**Subject:** Rezoning Petition Review

**Date of Review:** January 25, 2023

**Rezoning Petition #:** 22-155

**Location of Property:** Approximately 4.27 acres located along the south side of Lakeview Road, west of Trinity Road.

RZ.01

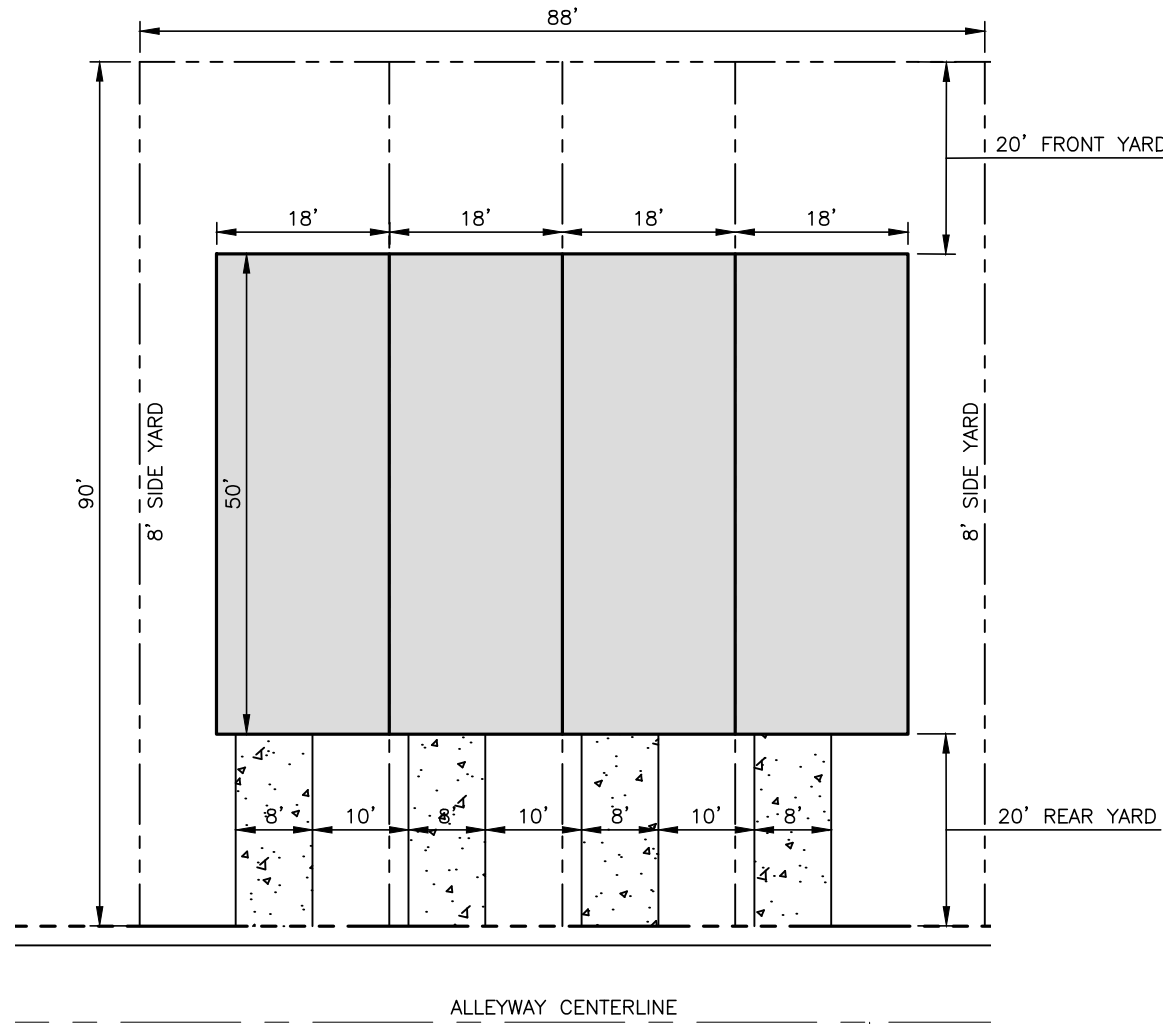
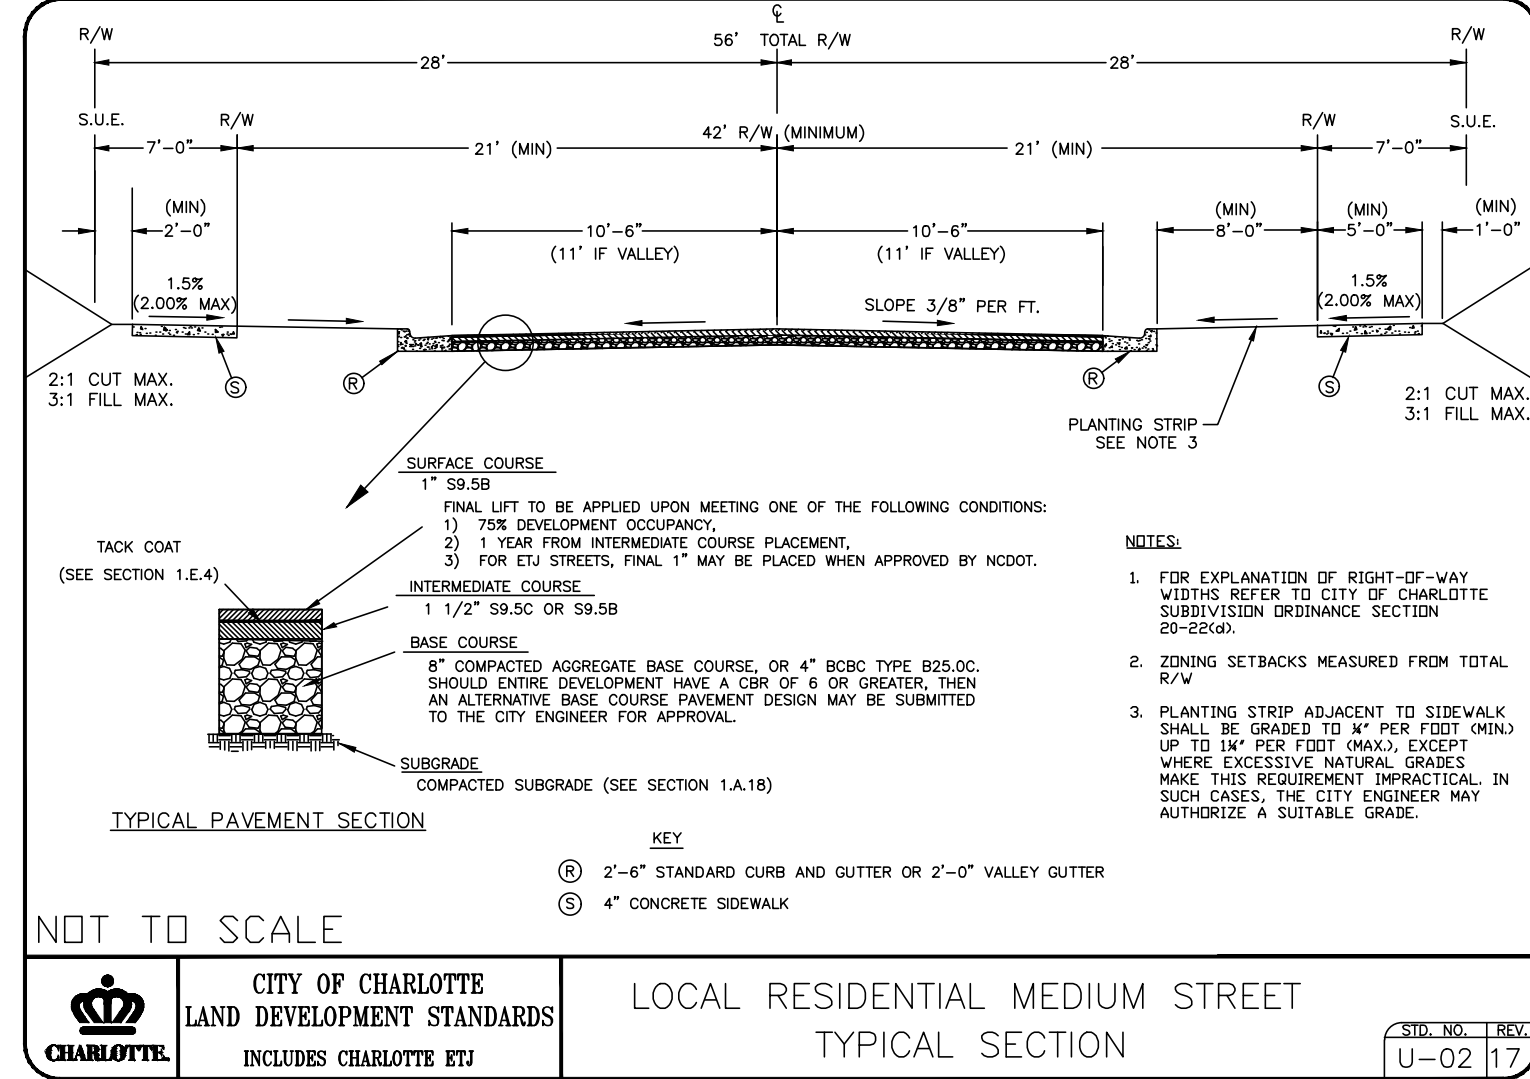
Please delineate and show all stream buffers on the site plan. Any increase of impervious area within such buffers may not be allowed. Please add under the Environmental Features heading to read as follows: "Development within the PCSO Buffer shall be coordinated with Charlotte-Mecklenburg Storm Water Services and mitigated if required by City ordinance."
